Application no: **3/2023/0073**

Address: **61 Mellor Brow Mellor BB2 7EX**

Proposal: **Proposed single-storey rear extension, replacement of existing external cladding, proposed car port, porch alterations and change of windows.**

The Local Highway Authority have viewed the plans and highway related documents and have the following comments to make:

Client		
Mr and Mrs Marsh		
Job Title		
Proposed Alterations to		
61 Mellor Brow		
Mellor		
Drawing Title		
Proposed Ground Floor Site Plan		
Scale		
1:100 @ A3		
Date		
Sept 2022		
Drawn		
BWT

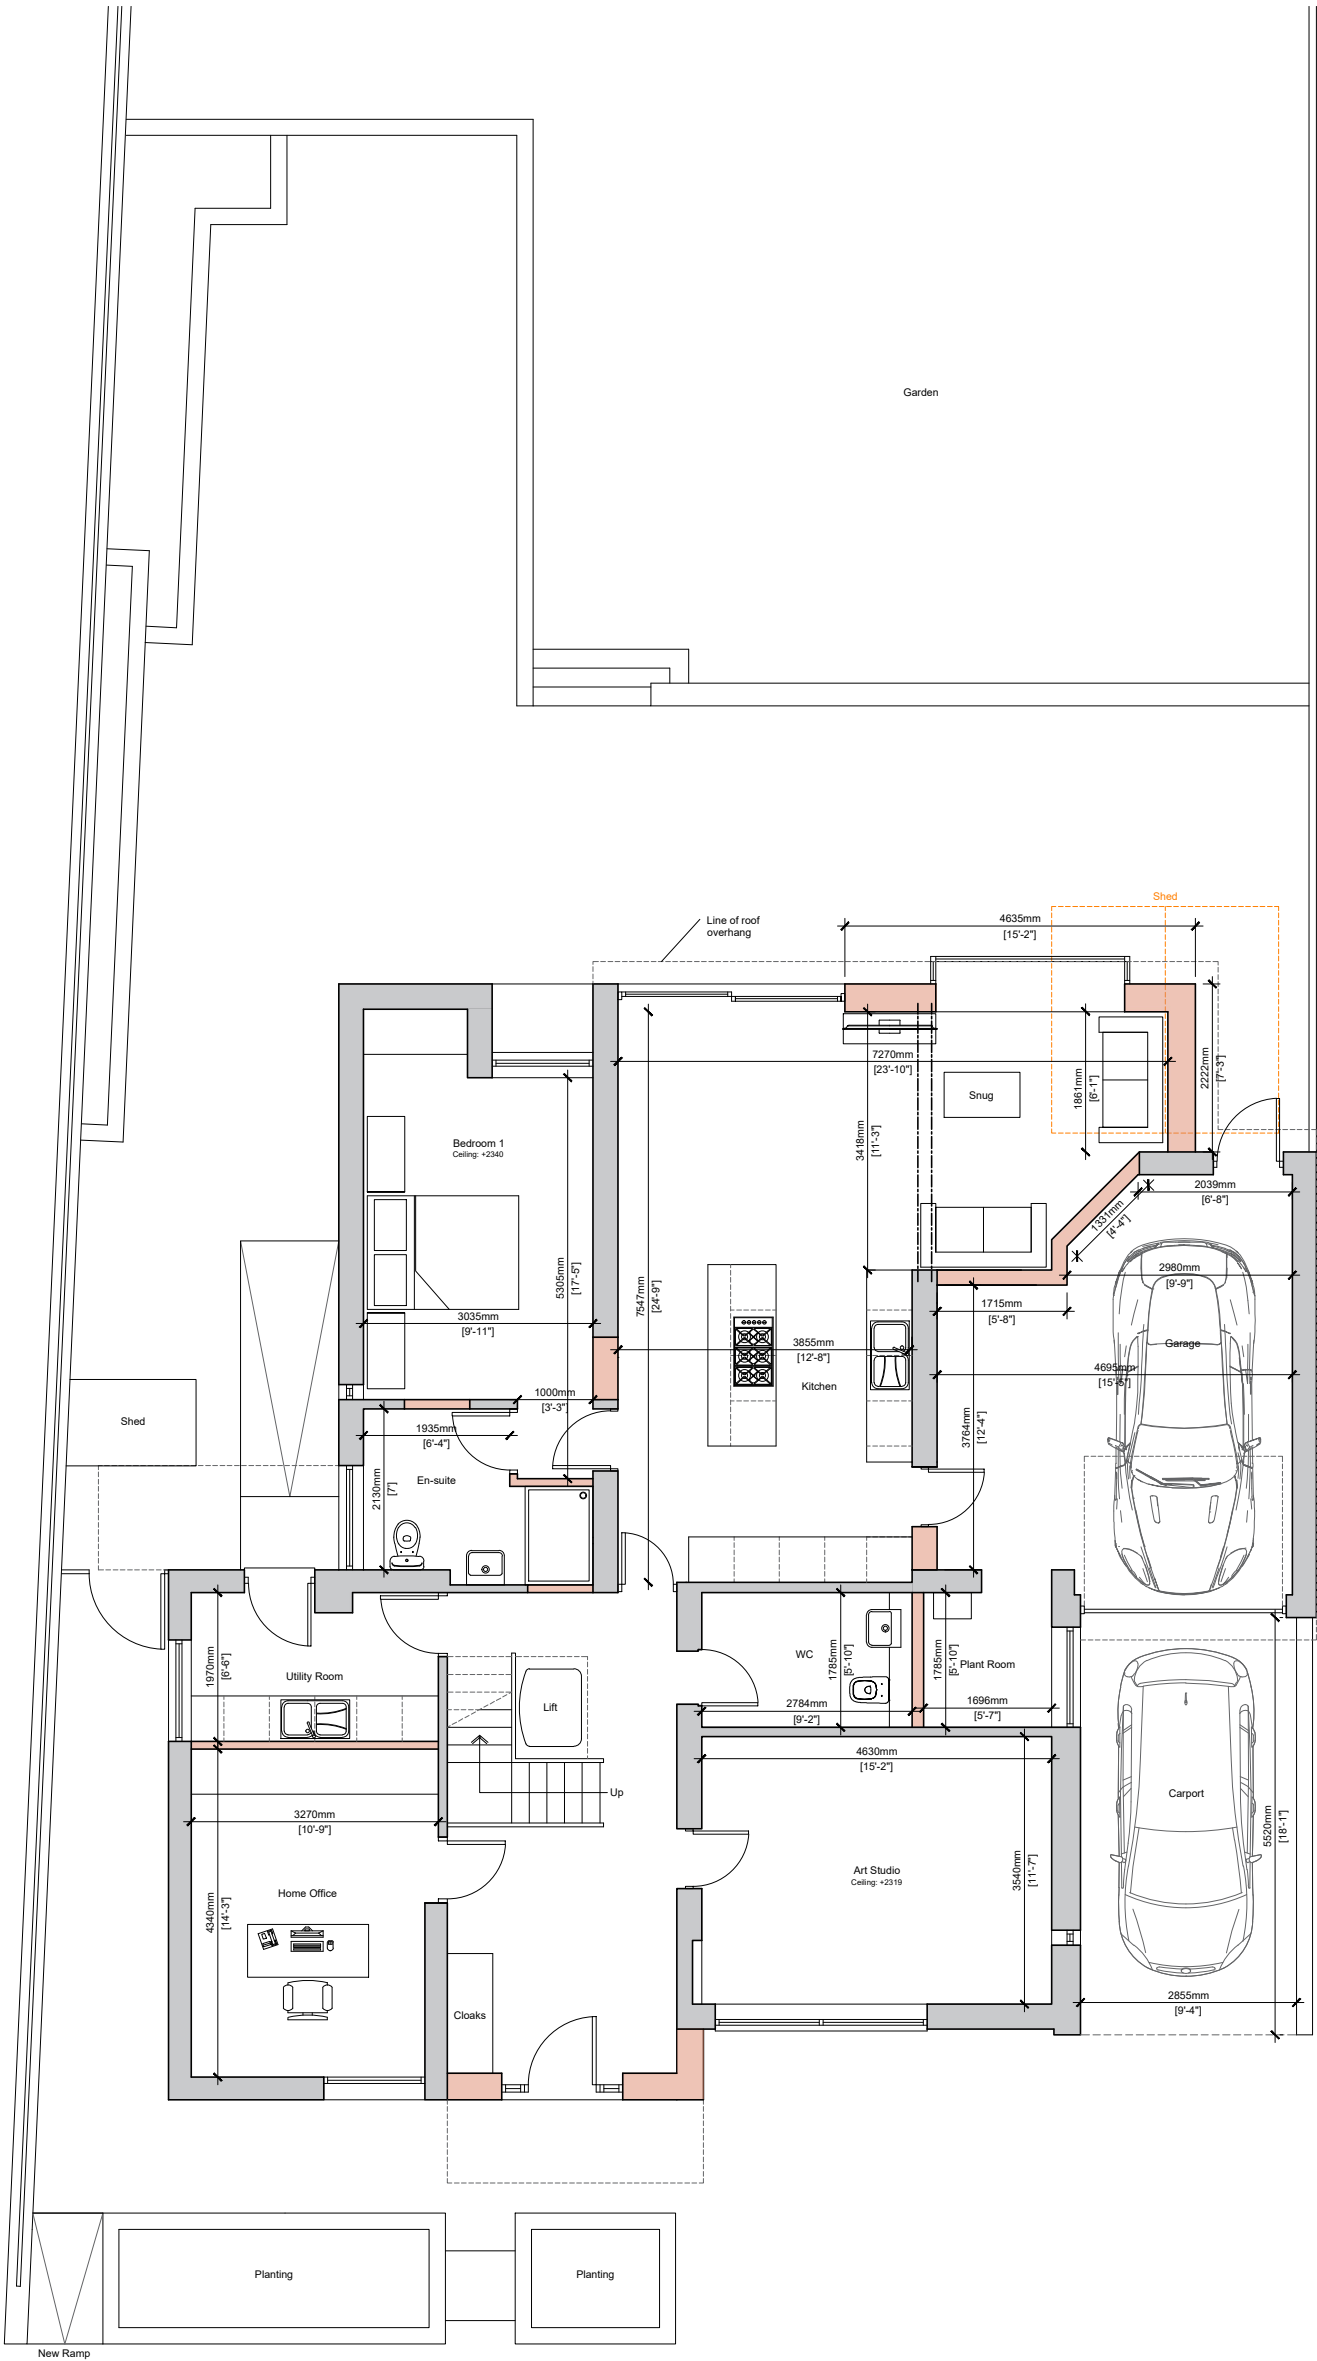
The LHA have reviewed the supporting documents and understands that the existing and proposed dwelling could potentially have 4 bedrooms should one of the additional rooms be converted. For the site to comply with the LHAs parking guidance as defined in the Joint Lancashire Structure Plan, the LHA require a minimum of 3 car parking spaces to be provided at the site.

The LHA have reviewed SPA drawing number 6739-P01 titled "Proposed Ground Floor Site Plan" and are aware that 2 car parking spaces can be provided at the site, with one being located in the proposed single garage and the other in the proposed car port.

While this will mean that the site will have a shortfall of one car parking space, the LHA will accept the shortfall. This is because the shortfall in parking is an existing situation and so the LHA have no objection to the proposal.

1. The development hereby permitted shall not be occupied until such time as the parking and turning facilities have been implemented in accordance with SPA drawing number 6739-P01. Thereafter the onsite parking provision shall be so maintained in perpetuity.

2. The garage and carport hereby approved shall be kept available for the parking of vehicles ancillary to the enjoyment of the household and shall not be used for any use that would preclude the ability of their use for the parking of private motor vehicles, whether or not permitted by the provisions of the Town and Country Planning (General Permitted Development) Order 2015 or any order amending or revoking and re-enacting that order.
